**Addendum No. 1**

RE: Contract ID C203803

**Cabarrus County (U-3440)**

NC-3 From Proposed West Side Bypass To SR-1691 (Loop Road)

| PROJECT REFERENCE NO. U-3440 | SHEET NO. UC-29 |

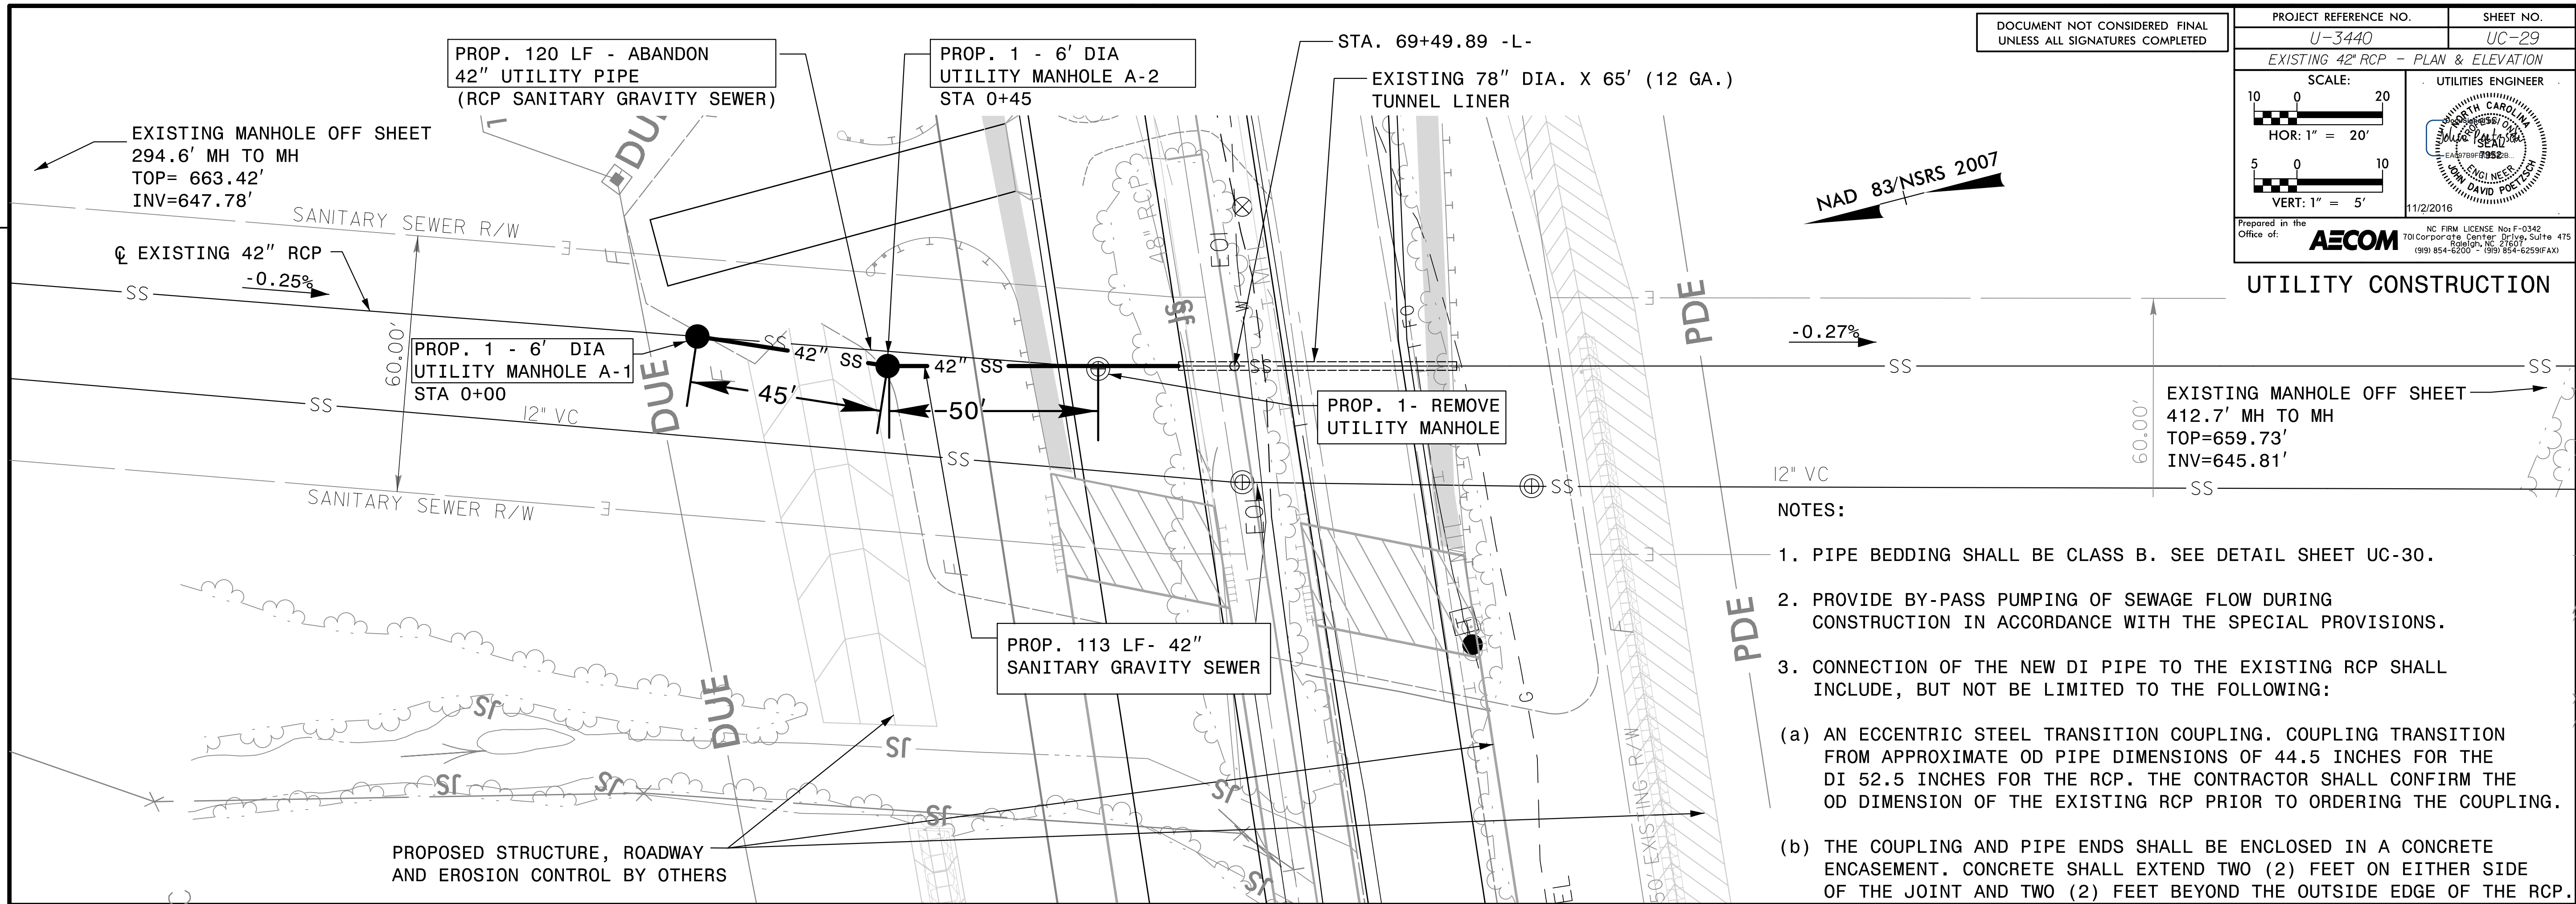
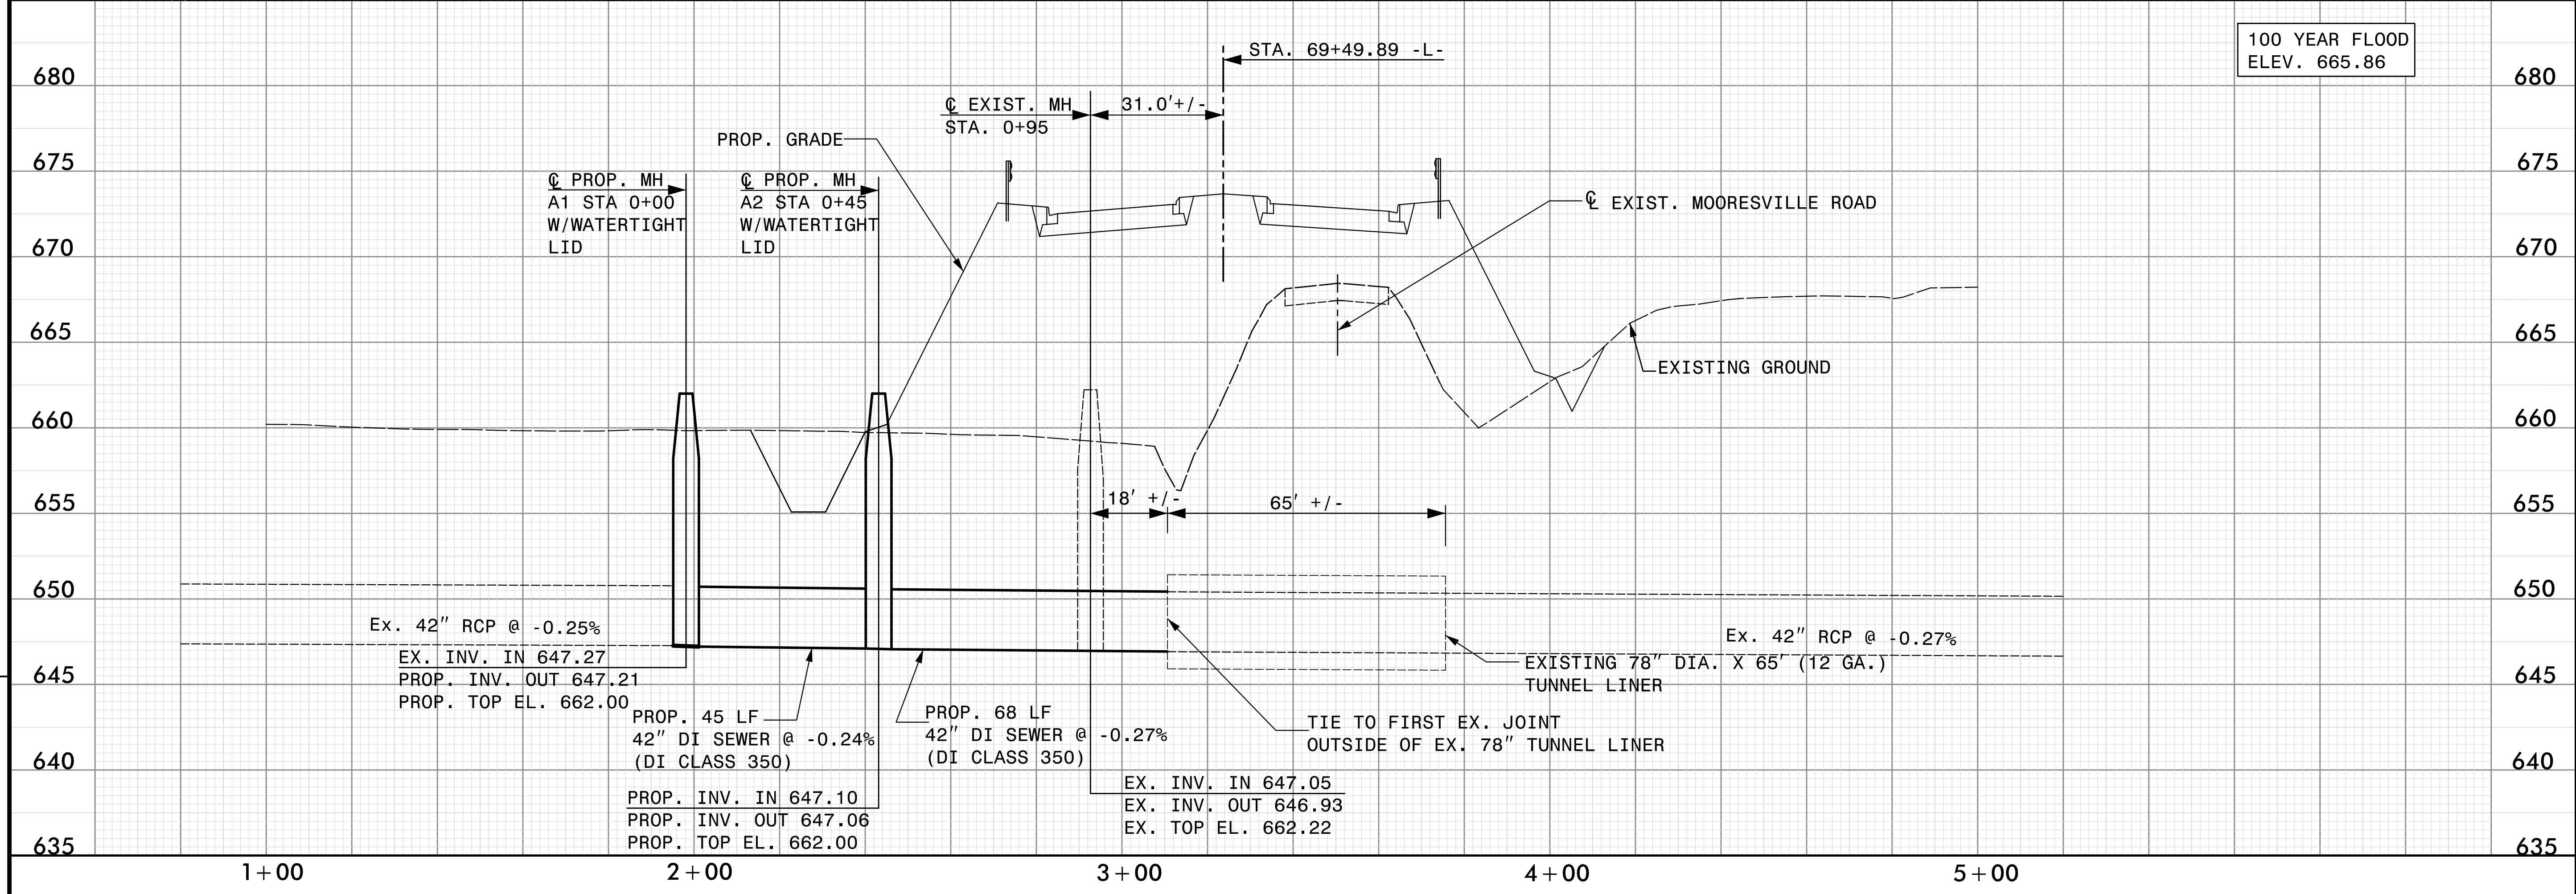
Sheet No.	Revisions
1A	Revised to indicate the addition of Sheet No. 2C-16
2C-16	New sheet to for detail for "Steel Plate Cover for Drainage Structure
UC-29	New sheet with 42" Sanitary Sewer added
UC-30	New sheet showing details of the new 6' Diameter Utility Manhole
W-5	Revised to include the value for the "maximum factored vertical pressure on foundation material"

Please add new Sheet Nos. UC-29 and UC-30 after existing Sheet No. UC-28. Please add New Sheet No. 2C-16 after existing Sheet No. 2C-15. Please void sheet Nos. 1A and W-5 in your plans and staple the revised sheets thereto.
